Our Ref : Cochlear Response to Submissions

SMEATON GRANGE SOFT DRINK MANUFACTURING PROJECT (08_0011)

This letter is written in response to the Department of Planning's (DoP) comments on the proposal (date 7 August 2008) and agency submissions received during the exhibition period for the above project. The agency submissions specifically addressed are:

Figure 1 – Site Plan

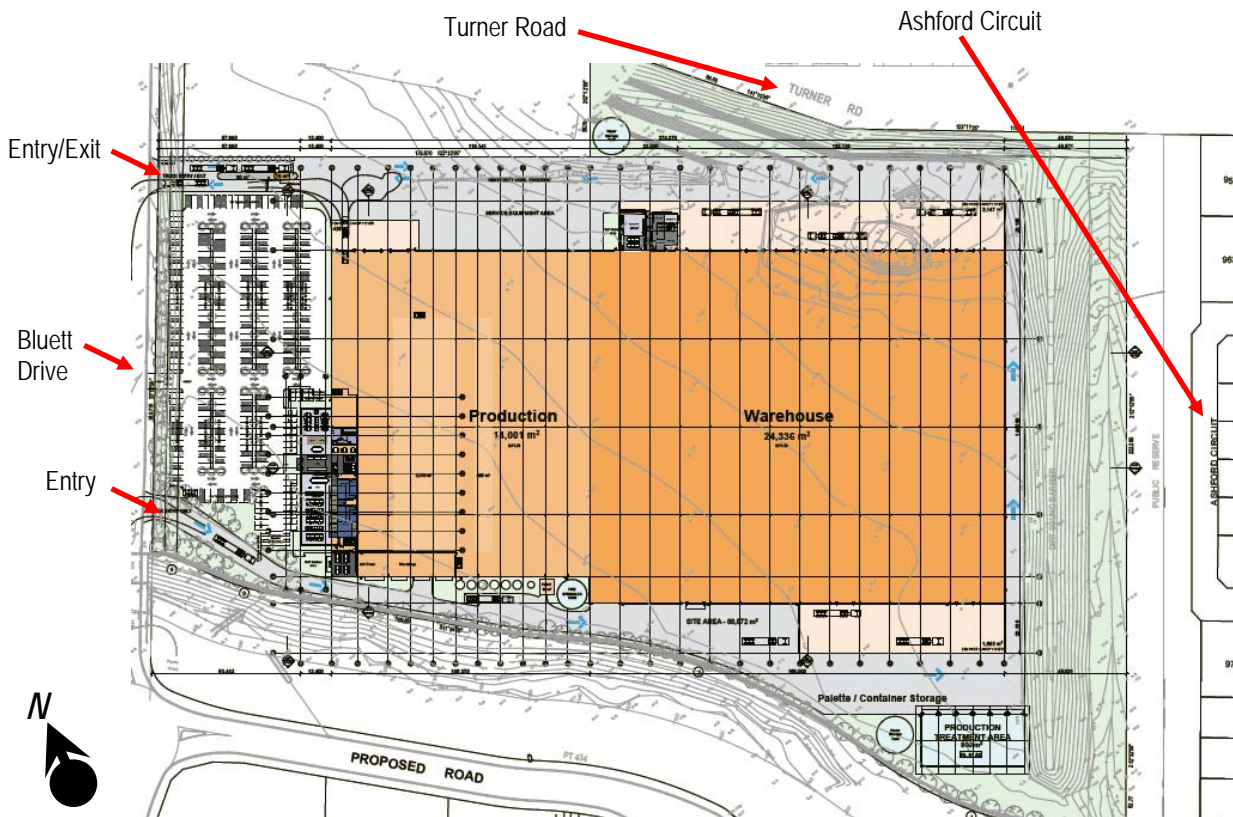
"The layout of the proposed car parking areas associated with the subject development (including, driveways, grades, turn paths, sight distance requirements, aisle widths, aisle lengths, and parking bay dimensions) should be in accordance with AS 2890.1 - 2004 and AS 2890.2 - 2002 for heavy vehicle usage"

"Provision of access and manoeuvring facilities for B-double size vehicles should be provided to allow operational flexibility for the facility in the future."

"The Department should ensure that the proposed entry/exit points from the site are compatible with the surrounding road network in terms of roundabout medians, street lighting and any other utility services present or still to be fully constructed. The entrances/exits should also be designed, in accordance with the relevant Australian Standards, to allow for entry and exit of the size of service vehicles/trucks that will use them"

A detailed review of the proposed car parking areas has been undertaken in the Traffic and Parking Impact Assessment (Section 4). The Swept Path analysis, also provided in Section 4, demonstrates that B-Double trucks will easily manoeuvre around the site, entering via the southern driveway access and exiting via the northern driveway access.

A review of the proposed entry/exit points from the site has been undertaken in the Traffic and Parking Impact Assessment (Section 4). Entrances comply with relevant Australian Standards as detailed in the Traffic Impact Assessment. The swept path analysis confirms that the proposed entrances/exits allow for entry and exit of the heavy vehicles including B-doubles, where required.
